Authority	Authority's Reference	Authority Contact	Authority Notification	Submission Due	Submission Made
NSW Planning, Industry & Environment	SSD-30759158	Nahid Mahmud	22/06/2022	25/07/2022	3/08/2022

Address	Land Title
268-278 Catherine Fields Road, Catherine Field	Lot 11 DP 833983, Lot 12 DP 833784

**Scope of Development Application or Planning Proposal**

Environmental Impact Statement (EIS) for the Minarah College, Catherine Field. New school for 1,500 students in Kindergarten to Year 12 including an Early Learning Centre and Special Education.

Figure 3.2 – Proposed Endeavour Energy Padmount Substation Location

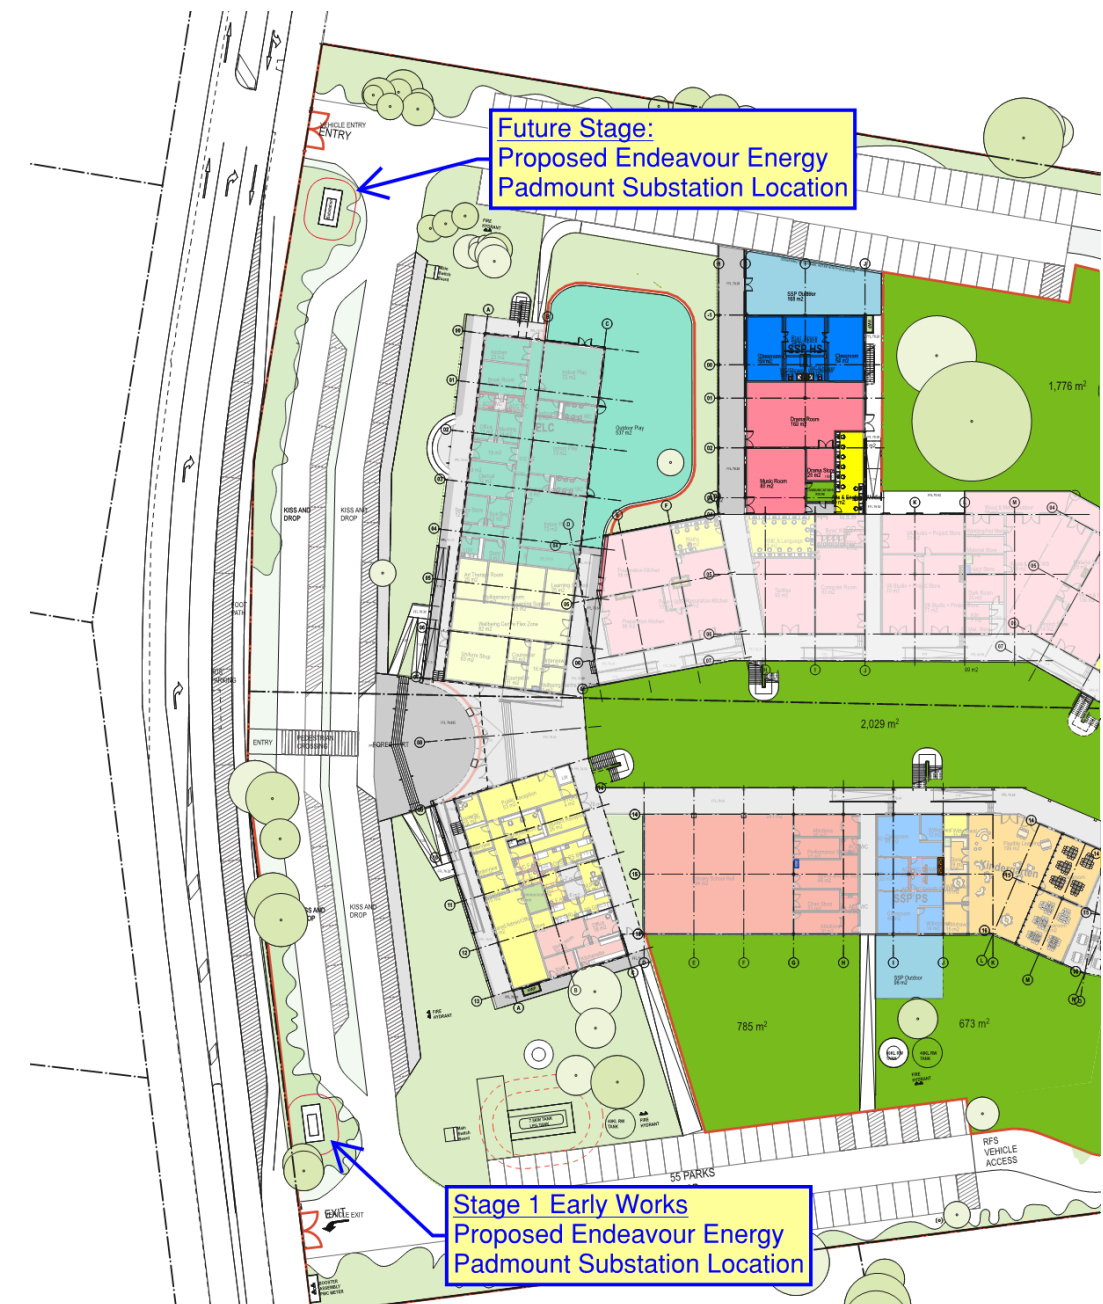
- The following extract of the Site Plan shows provision for two padmount substations.

- Any required padmount substation/s will need to be located within the property (in a suitable and accessible location) and be protected (including any associated cabling) by an easement and associated restrictions benefiting and gifted to Endeavour Energy. Please refer to Endeavour Energy's Mains Design Instruction MDI 0044 'Easements and Property Tenure Rights'.

- Endeavour Energy's 'Design certification checklist for ASP L3' the design must comply with Endeavour Energy's 'Earthing Design Instruction EDI 001 – Earthing design risk assessment' in which schools, pre-schools, day care centres are regarded as a 'special location'.

- Generally it is the Level 3 Accredited Service Provider's (ASP) responsibility (engaged by the developer) to make sure substation location and design complies with Endeavour Energy's standards the suitability of access, safety clearances, fire ratings, flooding etc.

- As well as the provision / capacity of the padmount substations, other factors such as the size and rating / load on the conductors and voltage drop (which can affect the quality of supply particularly with long conductor runs) etc. need to be assessed. However the extent of any works required will not be determined until the final load assessment is completed.

The proposed locations for the padmount substations in the front building setback / car park areas away from the school buildings is in keeping with the policy of prudent avoidance.

Screening vegetation around a padmount substation should be planted a minimum distance of 800mm plus half of the mature canopy width from the substation easement and have shallow / non-invasive roots. This is to avoid trees growing over the easement as falling branches may damage the cubicle and tree roots the underground cables. All vegetation is to be maintained in such a manner that it will allow unrestricted access by electrical workers to the substation easement all times.
